**Planning Application, Ribble Valley District
3/12/1002 18 King Street, Whalley**

Public Realm, Ribble Valley
LCC Environmental Services East
01254 828060

PROPOSED GROUND FLOOR PLAN
SCALE 1:50

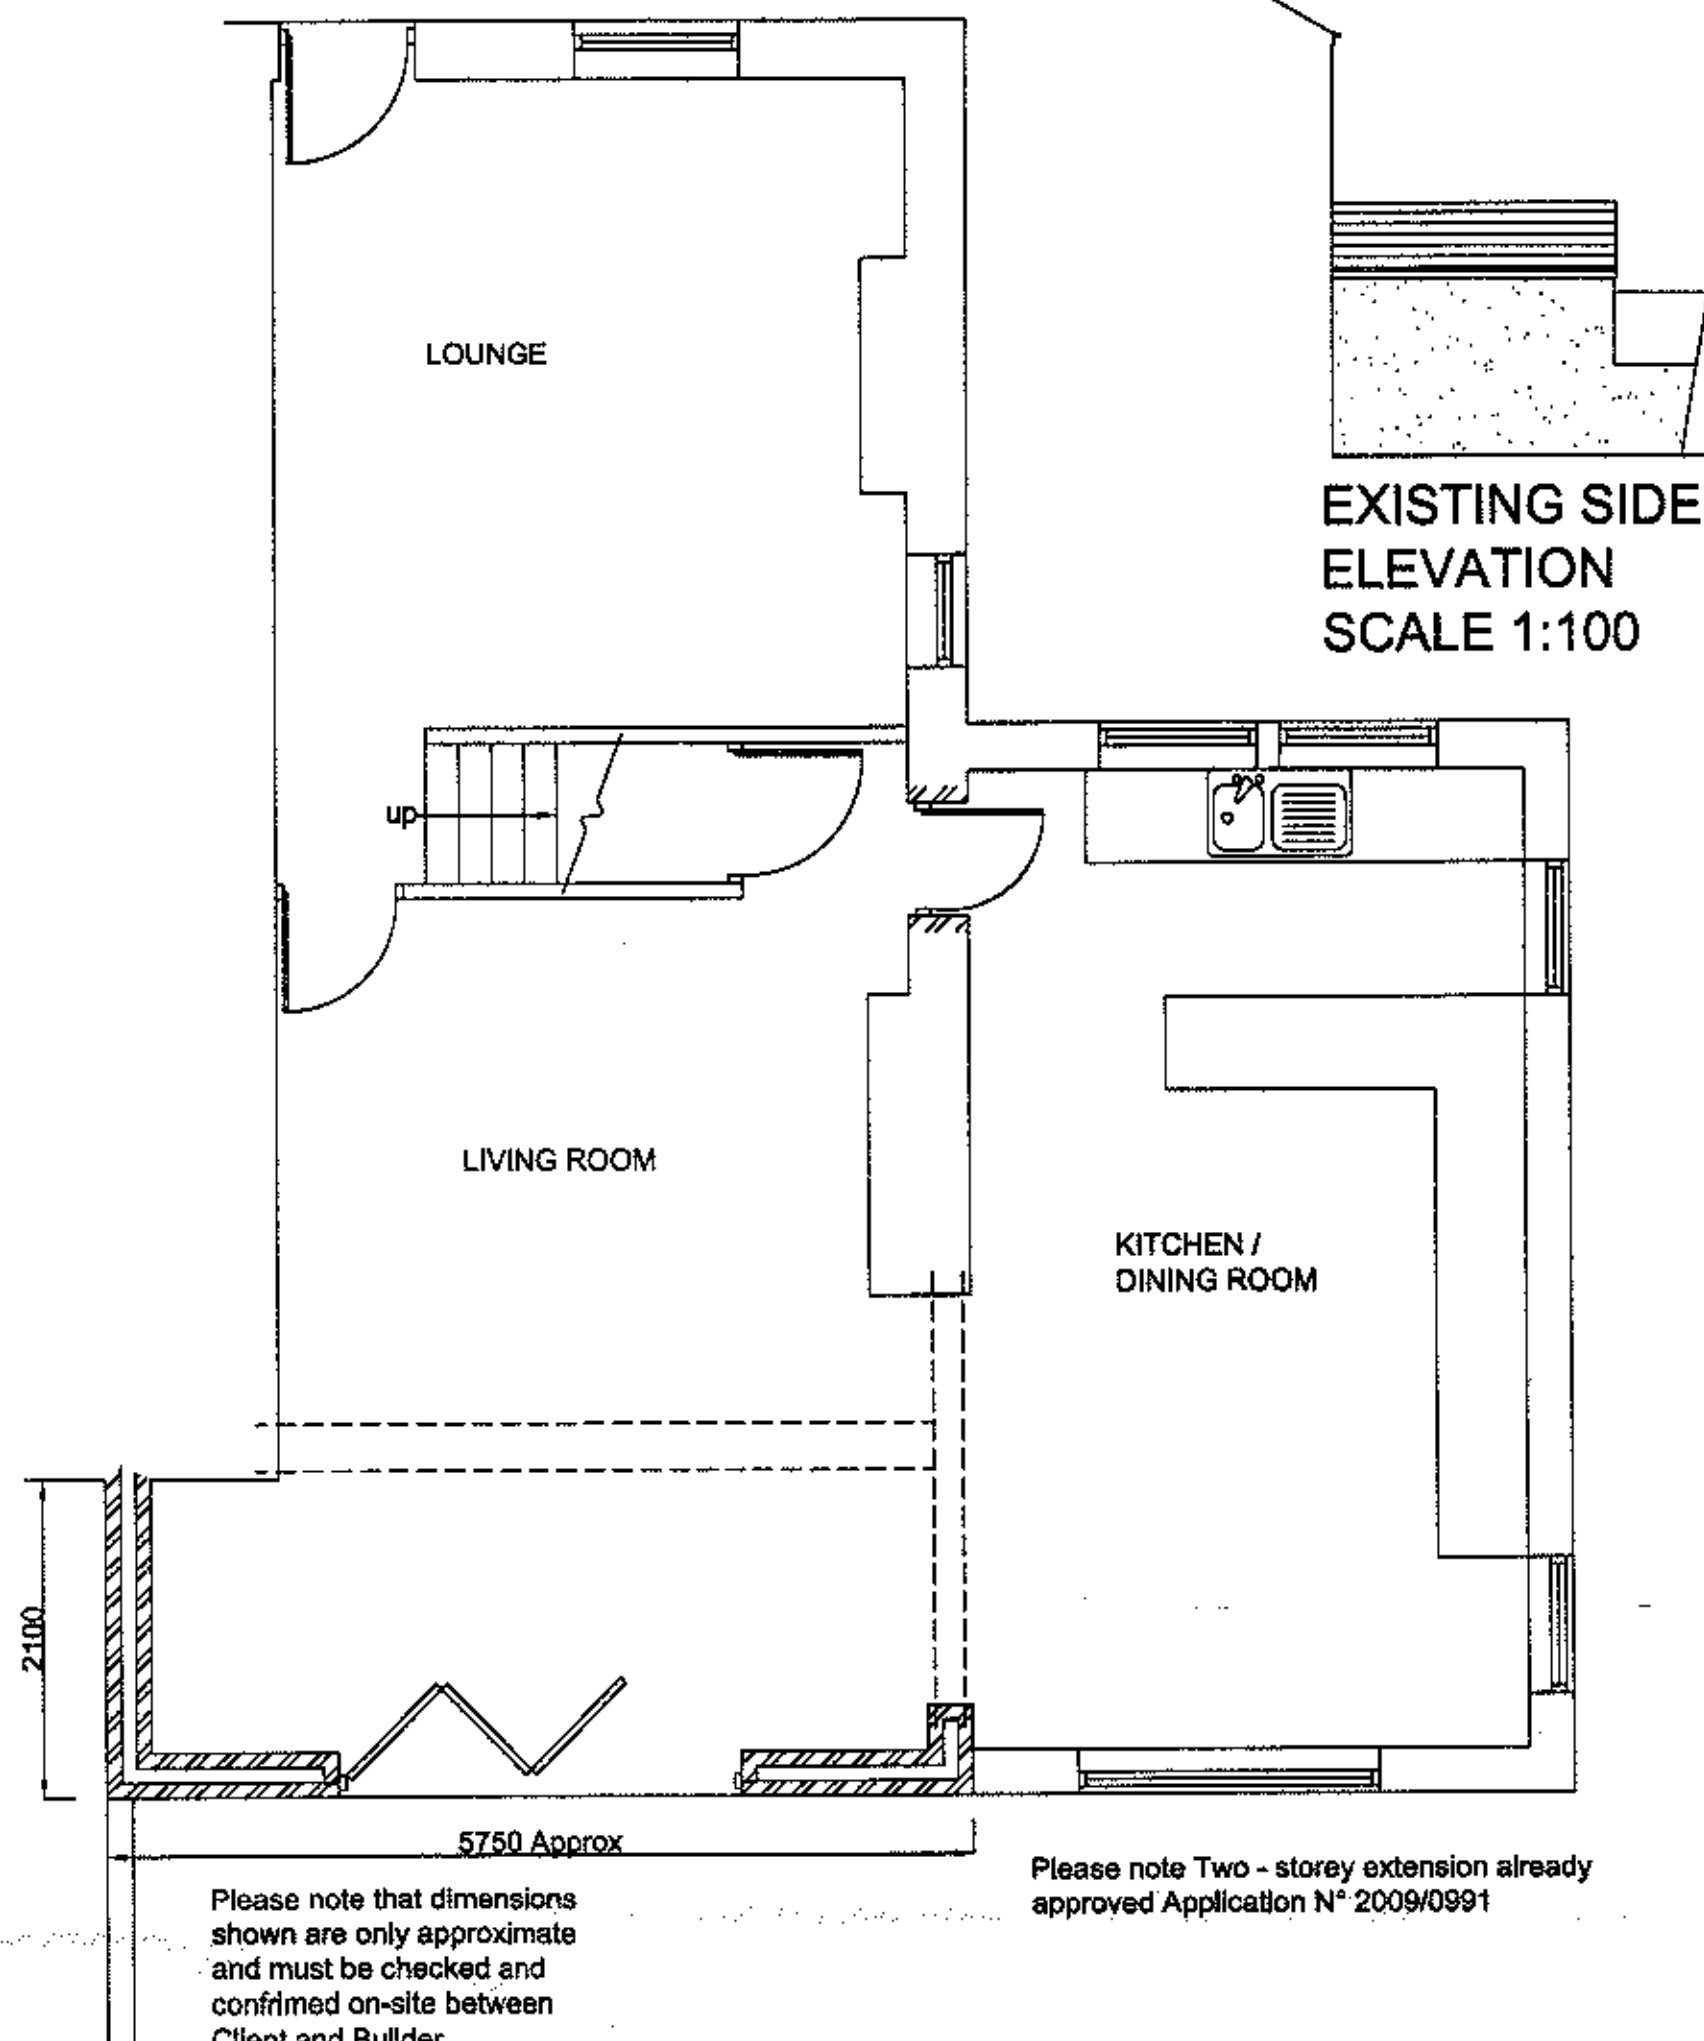
However, the gate leading from King Street is shown as being hinged on the inside of the entrance post. This will not allow the gate to open fully, to the extent that it will allow the second space will be accessible. For there to be full utility of these spaces there must be no physical impediment from the entrance gate. Therefore, I would wish to agree the details of a revised gate arrangement prior to consent being granted, should you be minded to approve the application.
